Ribble Valley Borough Council
Housing & Development Control

Application no: **3/2024/0020**

Address: **Alston Dairy Alston Lane Longridge PR3 3BL**

The Local Highway Authority have viewed the plans and highway related documents and have the following comments to make:

Proposed Outline Drainage Layout and Details

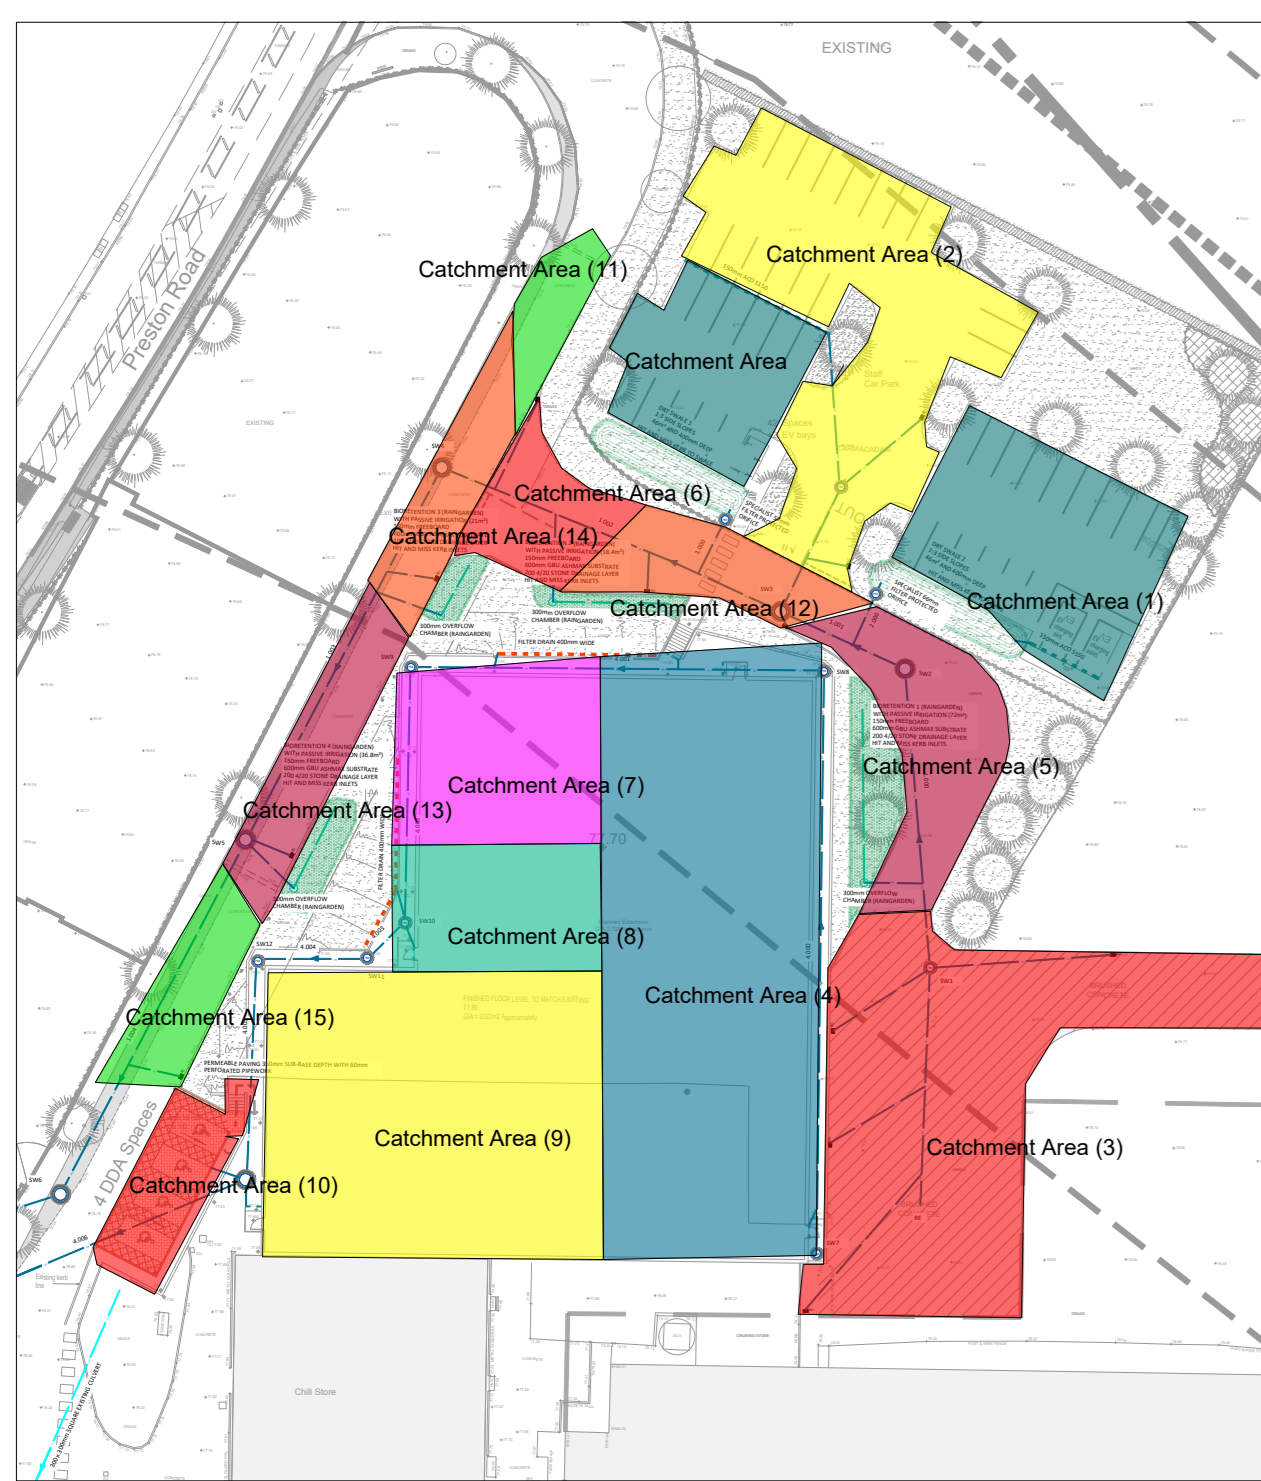
The LHA have reviewed Pluvian drawing number PN0107-XX-XX-DR-Y-0001 Rev P03 titled "Drainage Layout" and note that the sites surface water will connect to the culverted watercourse located in the adjacent field to the north of the site.

The LHA require the Applicant to gain separate consent from the Lead Local Flood Authority before connecting to the culverted watercourse. The LHA advise that discussions should be had now to investigate whether a connection to the watercourse will be acceptable.

Figure 1: Location of refuse store areas

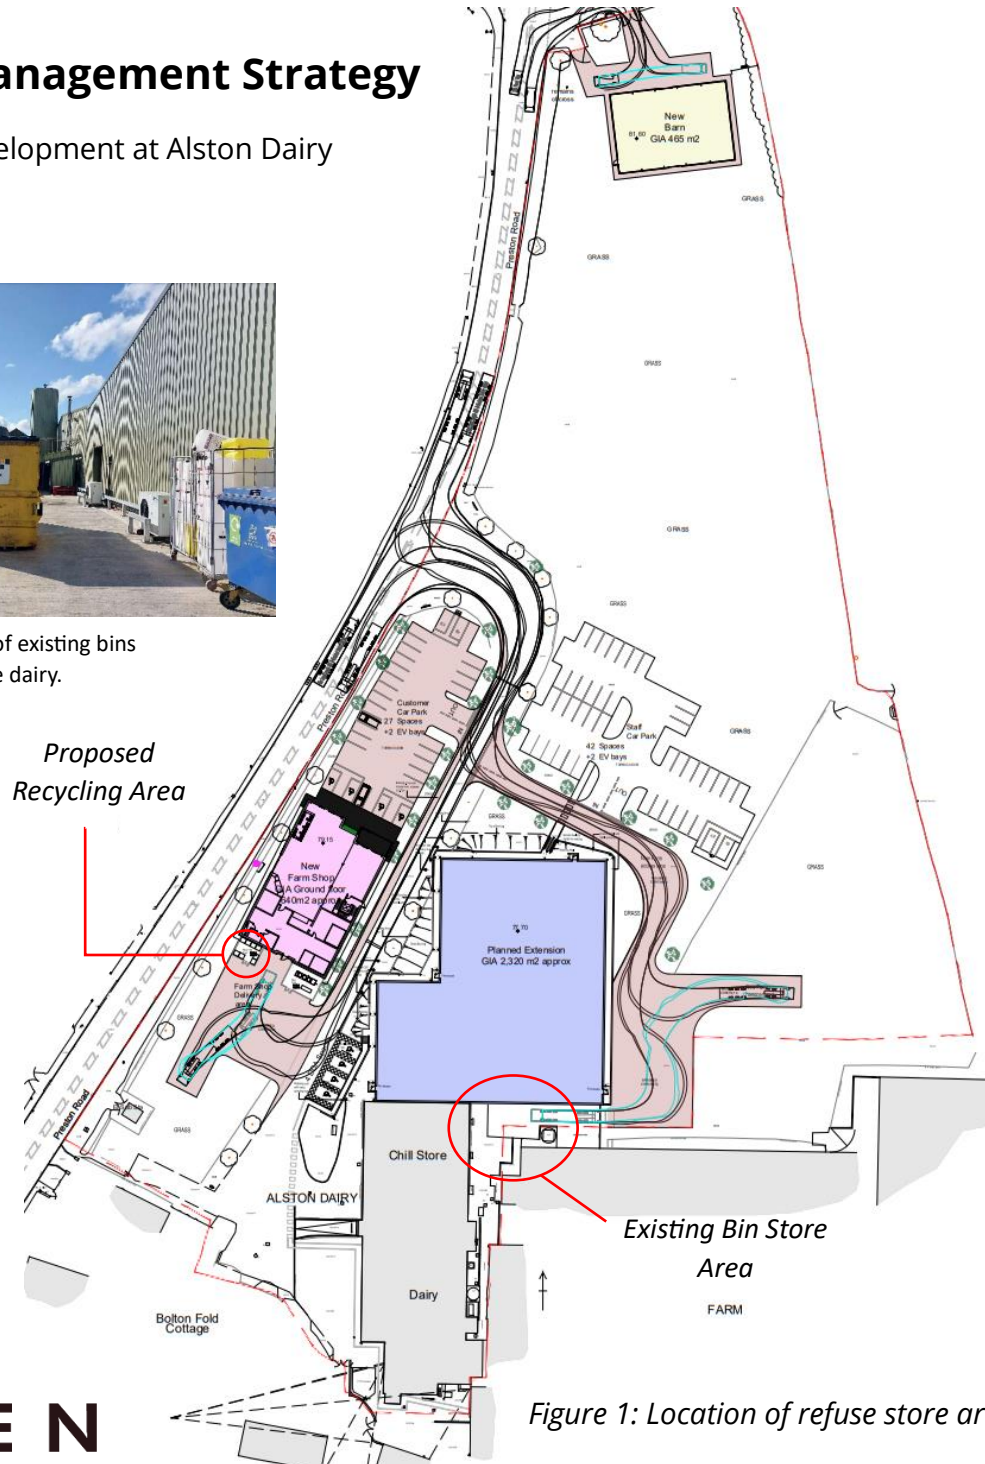
The LHA have reviewed the proposed Waste Management Plan and require further details regarding where refuse will be collected from for the proposed farm shop and café. This is because, as stated on the plan, the Agent has stated that on collection days bins will be transported to their dedicated collection point on site and returned upon collection. However, there are no details regarding where this will be. Therefore, the LHA require further information regarding the proposed bin collection point for the farm shop and café.

The LHA advise that waste for the farm shop and café is collected from the proposed servicing and turning area for the farm shop.
